Issue	Response
Tweed Shire Council	
<p>1. <u>Flooding and Stormwater</u></p> <p>Council’s initial review of the EIS raised significant flooding and stormwater concerns and these were forwarded directly to the proponent in an effort to streamline the assessment process. Whilst it is acknowledged that further information was provided to address Council’s initial concerns, the following further information is still required.</p> <p><u>Flood Impact Assessment</u></p> <p>a. It is recommended that the Flood Impact Assessment clarifies that no properties will be affected by increased flood levels as a result of the proposed Murwillumbah Education Campus development. Flooding is a particularly sensitive issue at the moment considering the recent major flooding events. The current wording of the Flood Impact Assessment is slightly vague in this regard.</p> <p><u>Stormwater Management</u></p> <p>b. The Stormwater Management Report is to be updated to advise how the additional ponding and flooding on adjacent roads caused by the proposed Murwillumbah Education Campus will be mitigated. Engineering drawings are to be provided demonstrate how this is appropriately managed.</p>	<p>a. A revised F

Figure 2 Location of Nest Boxes

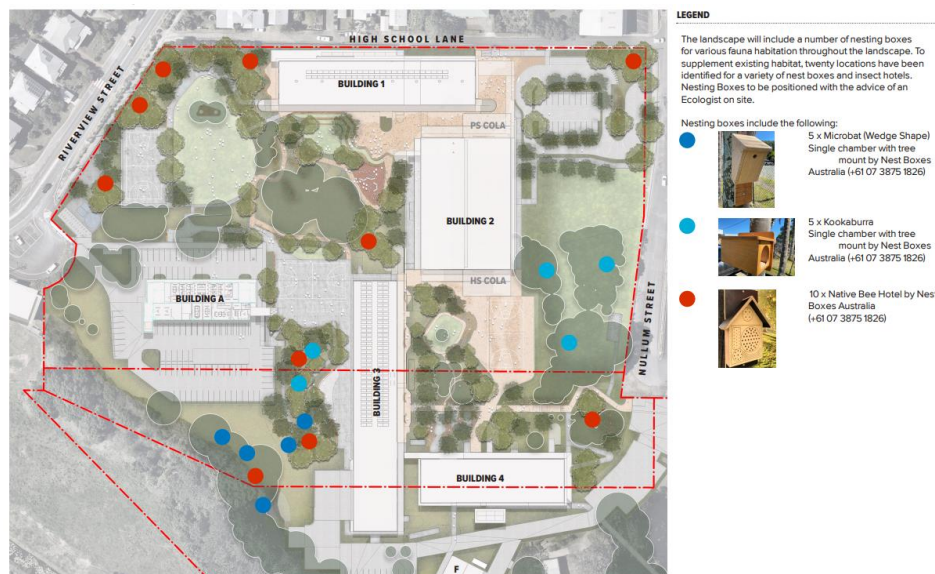
<p>d. The construction management plan indicates the location of a site shed right next to large rainforest trees to be retained. It is recommended that this shed be relocated to avoid any impact on these trees.</p>	<p>d. It is noted that the waste bin location identified in Appendix A of the revised CMP has not been modified. A note has been added which indicates that these trees are to be removed. It should be noted that the implications of this tree removal have been considered by both the ecologist and arborist in the revised BDAR and Arborist Report at Appendix O and Appendix R, respectively.</p> <p><i>(Submissions Report: Section 4.3 – Construction Management, p37)</i></p>
<p><u>Fauna</u></p> <p>e. The assessment of potential impacts in relation to fauna, including threatened species is supported. There may be opportunities to provide supplementary habitat for threatened microbat species in the proposed landscaping through the provision of nest boxes.</p>	<p>e. A revised Landscape Design Report has been prepared by Arcadia which can be found at Appendix P and provides the location for nest boxes. Their location is reproduced in Figure 2. The type of nest boxes and their locations have been verified by the project ecologist, EMM Consulting, as being suitable.</p>  <p>Figure 2 Location of Nest Boxes</p> <p><i>(Submissions Report: Section 4.3 – Fauna, p32)</i></p>
